Subject: FW: Application Reference CM/64/19/PL Langford, Climping

Could the below email be uploaded onto the above application file and labelled as 'Agent Response to Parish Council Objection' please?

As discussed we are pleased to provide a response to the various points raised by Climping Parish Council in response to our client's application at Langford.

New site entrance and 8m footway link between new site entrance and existing footway in Apple Tree Walk to be constructed in accordance with West Sussex CC details and subject to Section 278 Agreement

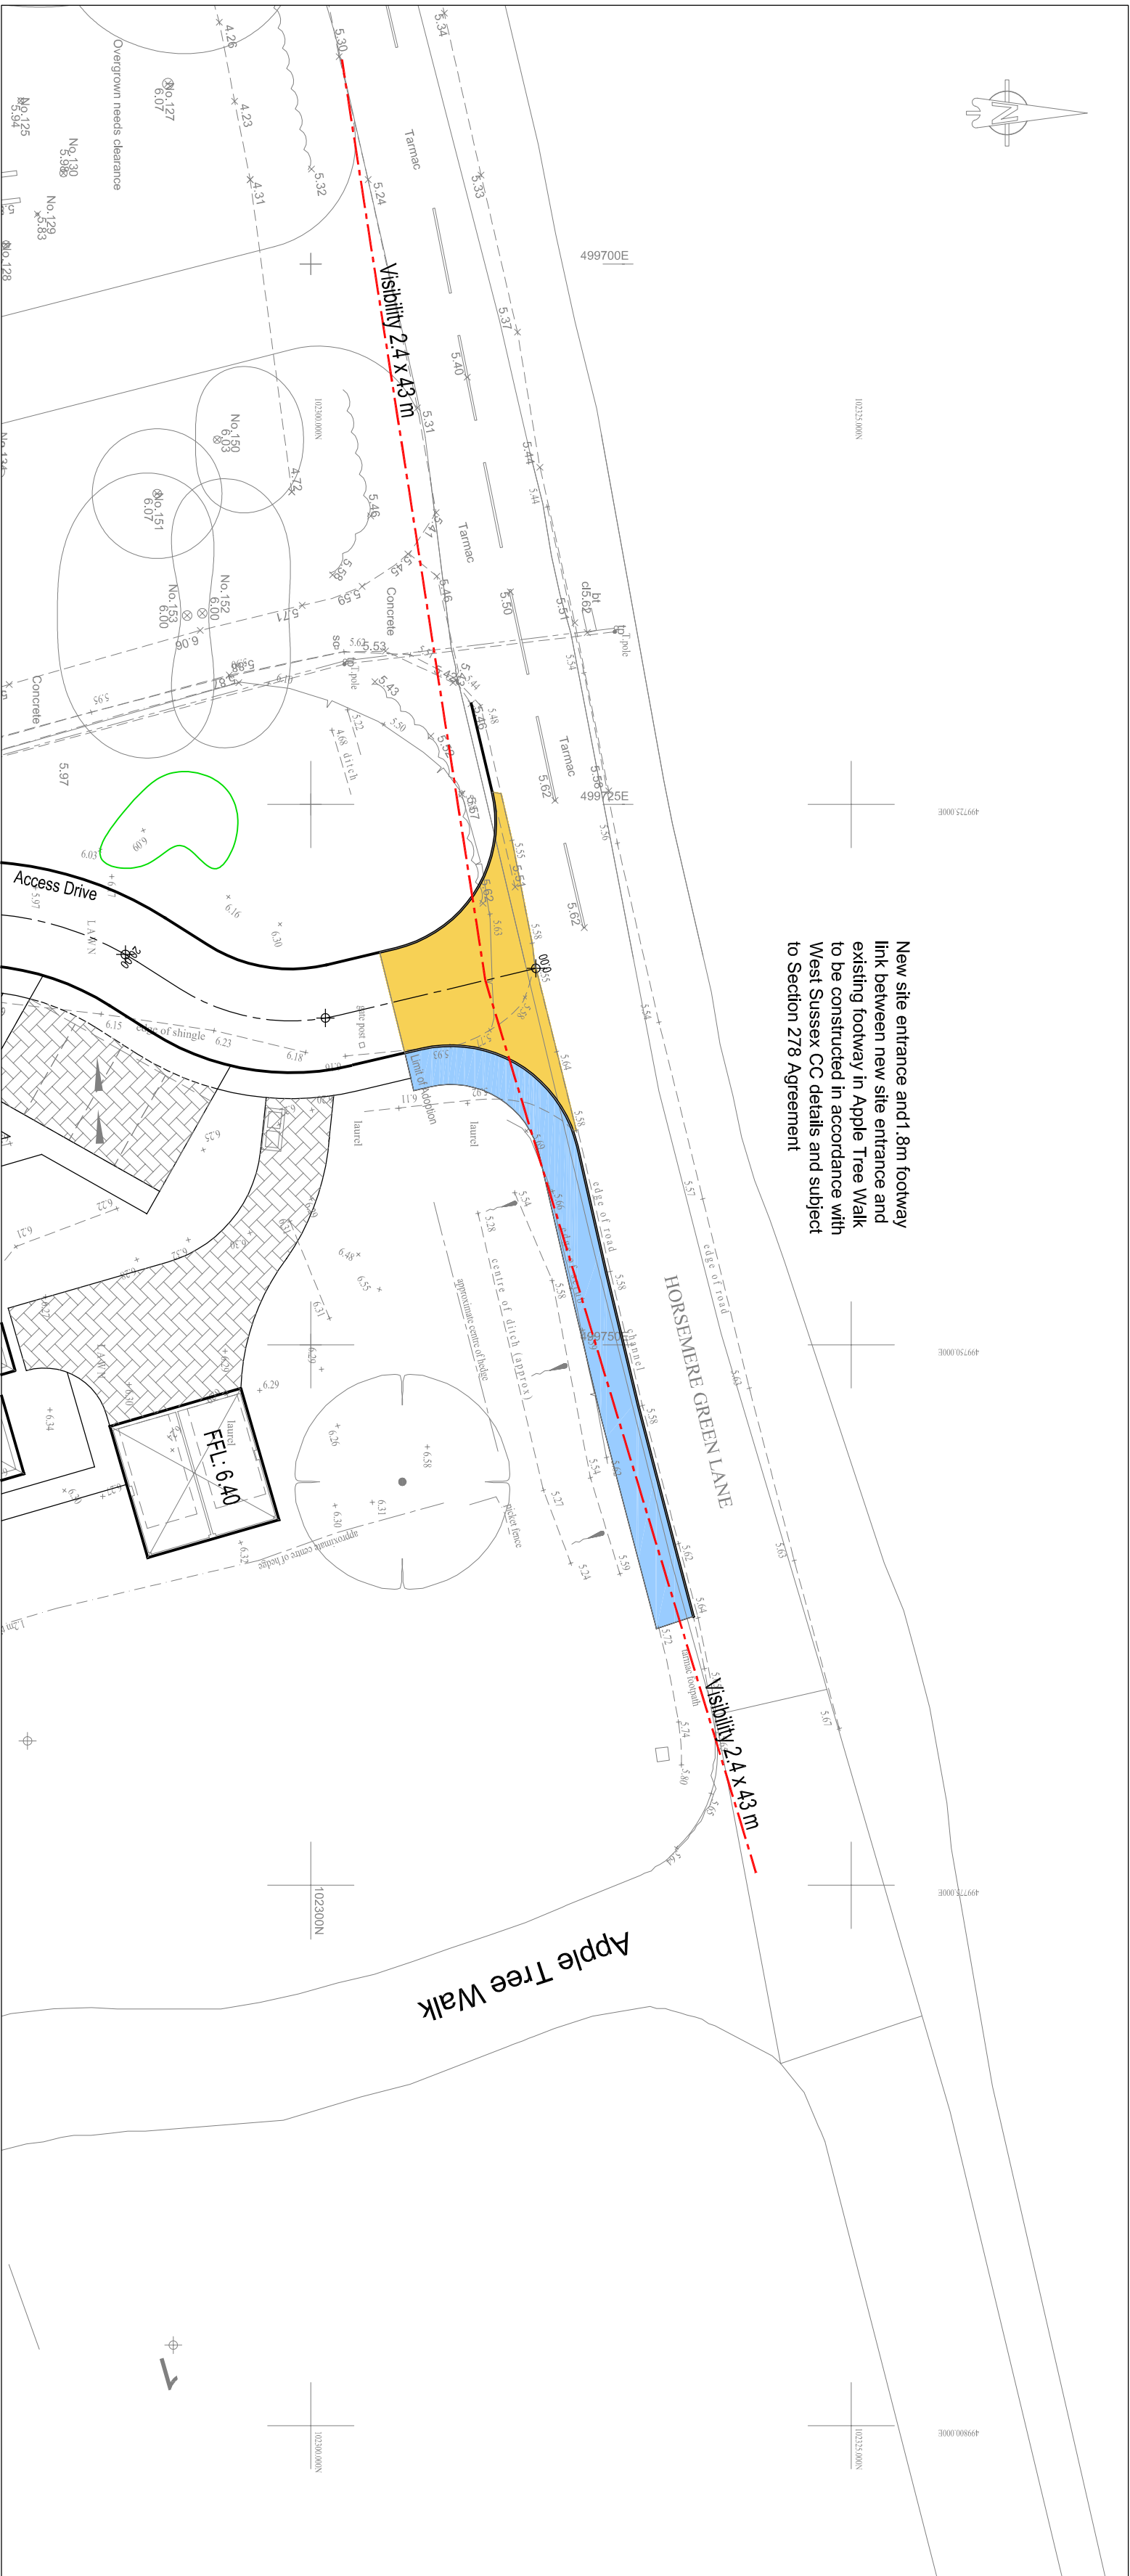
Lastly, the Parish Council raised concern in respect of the inability of schemes of this size to secure upgrades to the local footway network. I am sure the Parish will be pleased to note that it is indeed intended to provide an upgrade to the footway leading between Appletree Walk and then into the site, a set of works that will be secured by way of a S278 agreement.
